From: Laura Gibbons <Laura.Gibbons@arun.gov.uk>
Sent: 14 October 2019 09:52
To: Planning.Responses <Planning.Responses@arun.gov.uk>
Cc: Anita Gardner <Anita.Gardner@arun.gov.uk>
Subject: RE: Planning Consultation on: EP/124/19/PL

Engineers Comments

APPLICATION NO: EP/124/19/PL

Description of Works: 1 No. new detached single storey dwelling with associated access driveway & external works.

Image below: proposed block plan (n.t.s.)

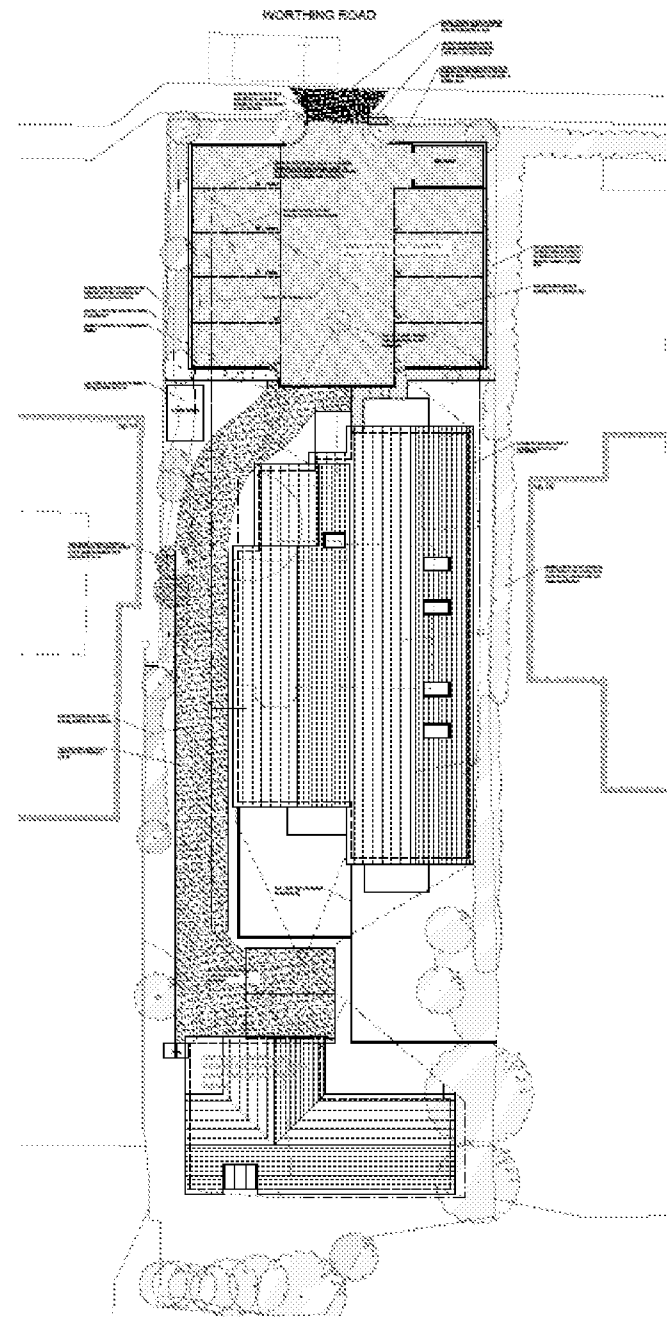
There is no objection in principle to the proposed building. However no consideration has been given for how the new structure will be drained. Application EP/109/19/PL for the flats on the same site indicates that the applicant intends to site a soakaway south of the flats (north of this dwelling). However, no winter groundwater monitoring or infiltration testing have been submitted, nor a detailed drainage design. A soakaway requires 5m easement from buildings in all directions. Without knowing the dimensions of the soakaway required to drain the flats, it is not possible to confirm the viability of constructing both buildings on the site. In addition, the site will require extra capacity to drain the new detached dwelling which was omitted from the application for the flats.

If you are minded to approve the application please apply the following conditions to ensure that the development is adequately drained and does not increase flood risk elsewhere.

"Development shall not commence, other than works of site survey and investigation, until full details of the proposed surface water drainage scheme have been submitted to and approved in writing by the Local Planning Authority. The design should follow the hierarchy of preference for different types of surface water drainage disposal systems as set out in Approved Document H of the Building Regulations, and the recommendations of the SuDS Manual produced by CIRIA. Winter groundwater monitoring to establish highest annual ground water levels and winter Percolation testing to BRE 365, or similar approved, will be required to support the design of any Infiltration drainage. No building / No part of the extended building shall be occupied until the complete surface water drainage system serving the property has been implemented in accordance with the agreed details and the details so agreed shall be maintained in good working order in perpetuity."
